Your ref: SSD-81434988
Our ref: DOC26/230953

Subject: Response to Submissions – Alspeck Warehousing Facility (SSD-81434988) (Penrith)

CPHR comments on Response to Submissions – Alspec Warehousing Facility (SSD - 81434988) (Penrith)

EASTERN CATCHMENT TOTAL SITE =54,354m²

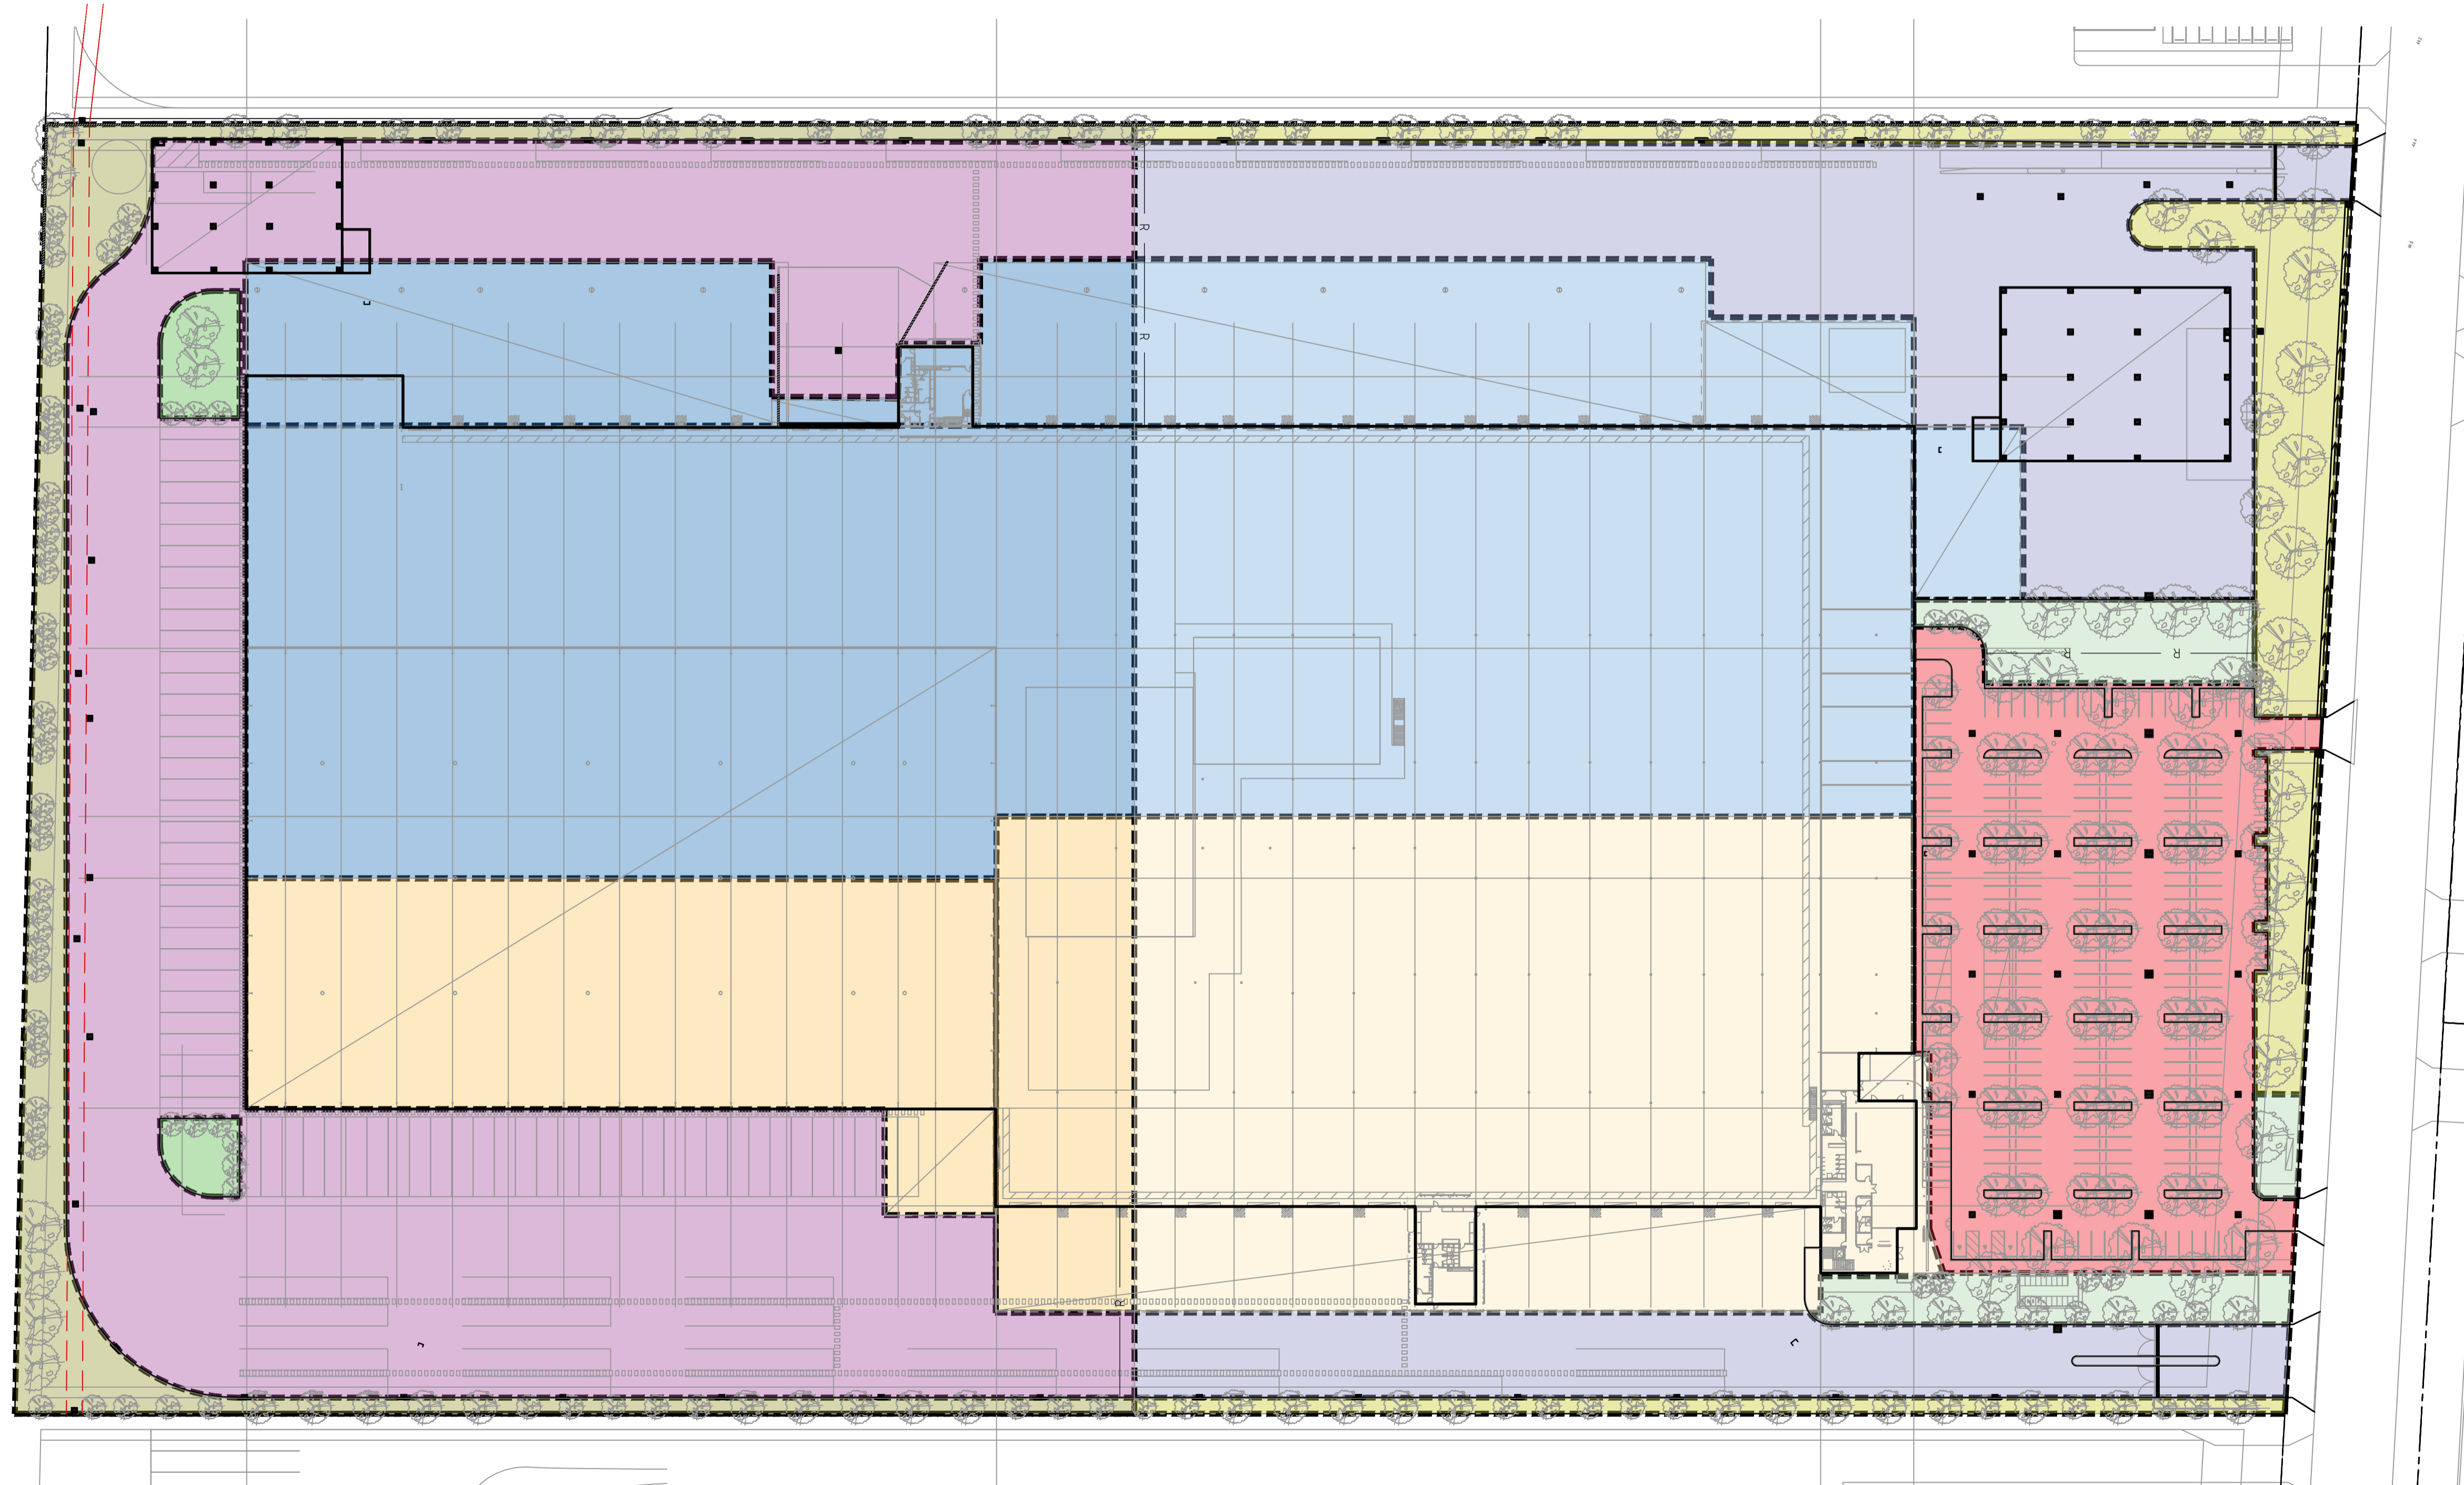
1.	<i>Compliance with the Wianamatta-South Creek stormwater management targets – stormwater management strategy</i>	The subject lot for this State significant development (SSD) appears to form a large portion of the northern catchment in the Penrith City Council development application (DA24/0294) approval for Bulk Earthworks across the broader site. The approved Integrated Water Cycle Management (IWCM) strategy for DA24/0294 includes the following measures: • gross pollutant traps (GPTs) • bioretention system • pond • large irrigation areas. CPHR notes that the additional information focuses on the Alspec site only and does not provide details on which of the above measures are being constructed with this SSD. Part or all of these development scale initiatives must be delivered to support this SSD. Recommended action: • Provide clarification regarding what infrastructure (including interim and ultimate) will be constructed as part of this SSD. • If all the infrastructure outlined in DA24/0294 is to be delivered prior to this SSD, then this should be confirmed in writing so it can form a condition of consent. • If only part of the infrastructure in DA24/0294 is to be delivered, then the extent of this infrastructure (or alternative interim infrastructure) should be confirmed. A report and associated modelling should also be provided which outline how this achieves the Wianamatta-South Creek stormwater management targets.

SEDIMENT & EROSION CONTROL NOTES

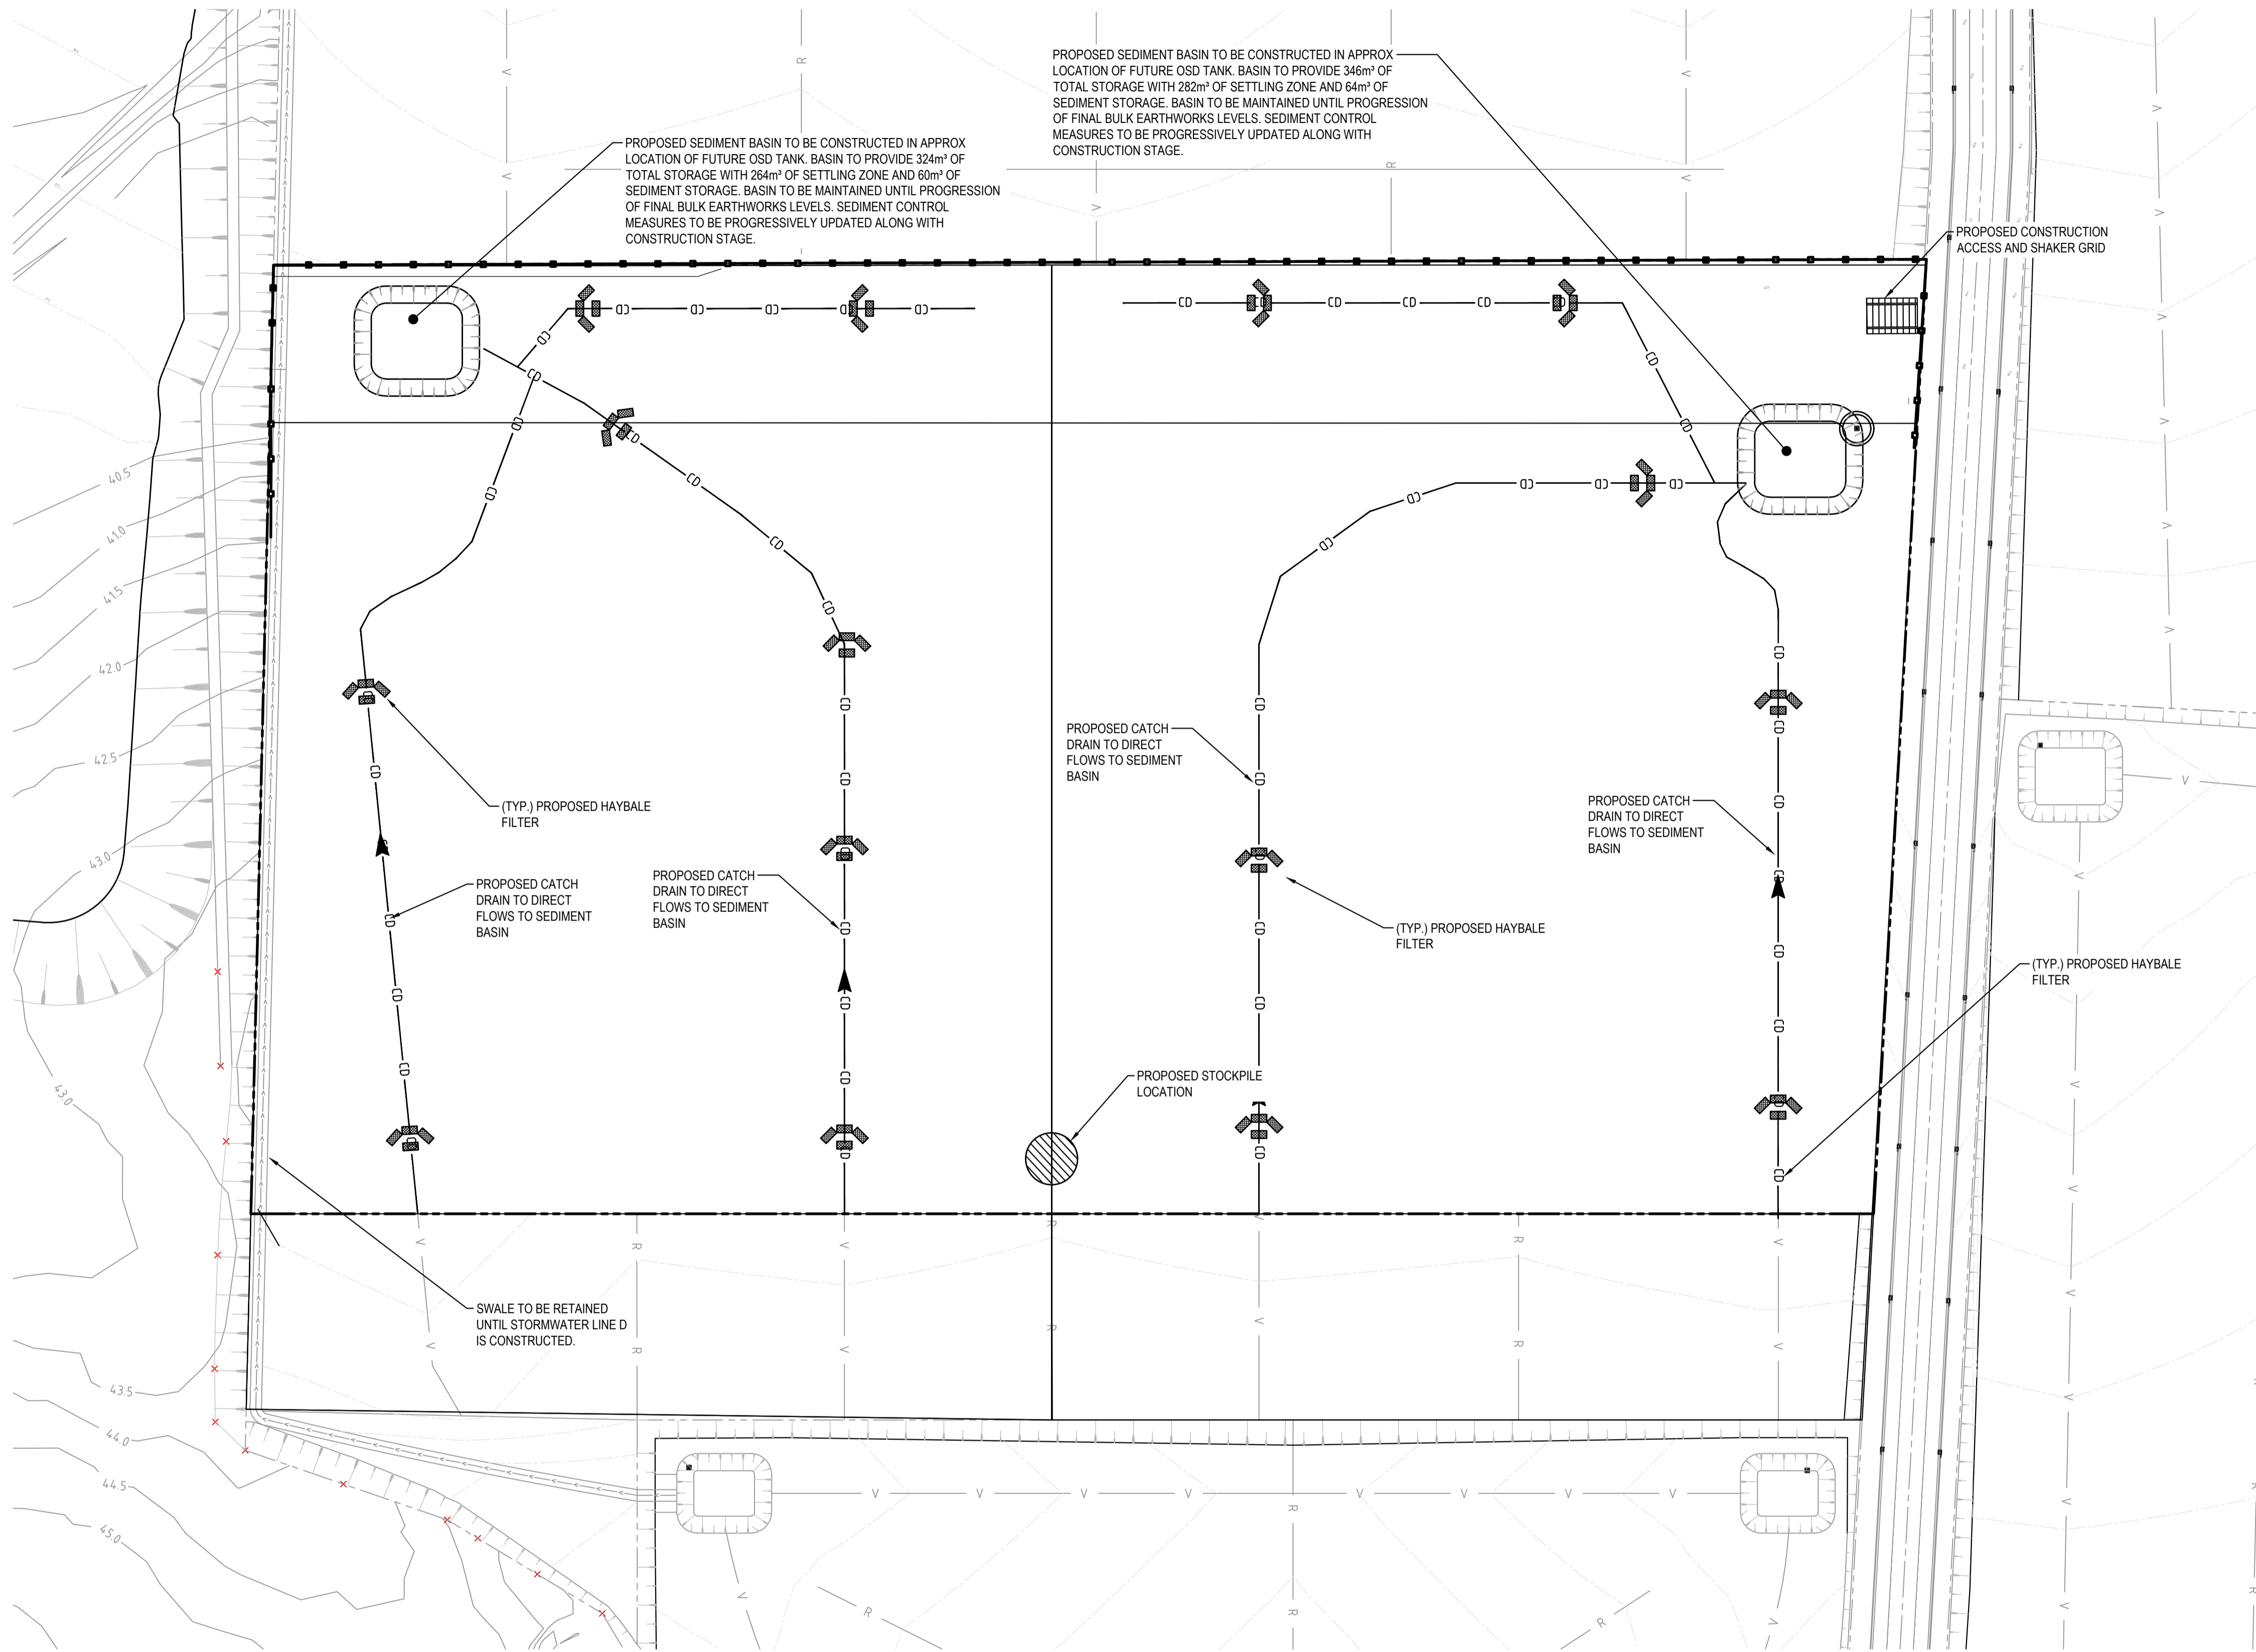
2.	<i>Compliance with the Wianamatta-South Creek stormwater management targets – erosion and sedimentation controls</i>	To demonstrate the construction phase stormwater quality targets will be met, a detailed erosion and sediment control plan (ESCP) must: • be developed and certified by a Certified Professional in Erosion and Sediment Control or a qualified and experienced civil engineer with at least 5 years' experience in the development of site-specific soil and water management plans • illustrate appropriate controls, that when implemented will achieve the construction phase stormwater quality targets in Table 2 of the Technical guidance for achieving Wianamatta-South Creek stormwater management targets (DPE, 2022) (the Tech Guide) • provide relevant calculations in particular for high efficiency sediment basins which are typically required to achieve the targets • be prepared in accordance with the Blue Book (NSW Government 2004) • be prepared in accordance with the Water Sensitive Urban Design (WSUD) design considerations set out in Chapter 3 of the Tech Guide (especially WSUD measures) provide conceptual designs that include the site, catchment and key features of the ESCP on scaled drawings. Recommended action: • Provide detailed ESCP and associated design drawings demonstrating compliance with construction phase stormwater targets.
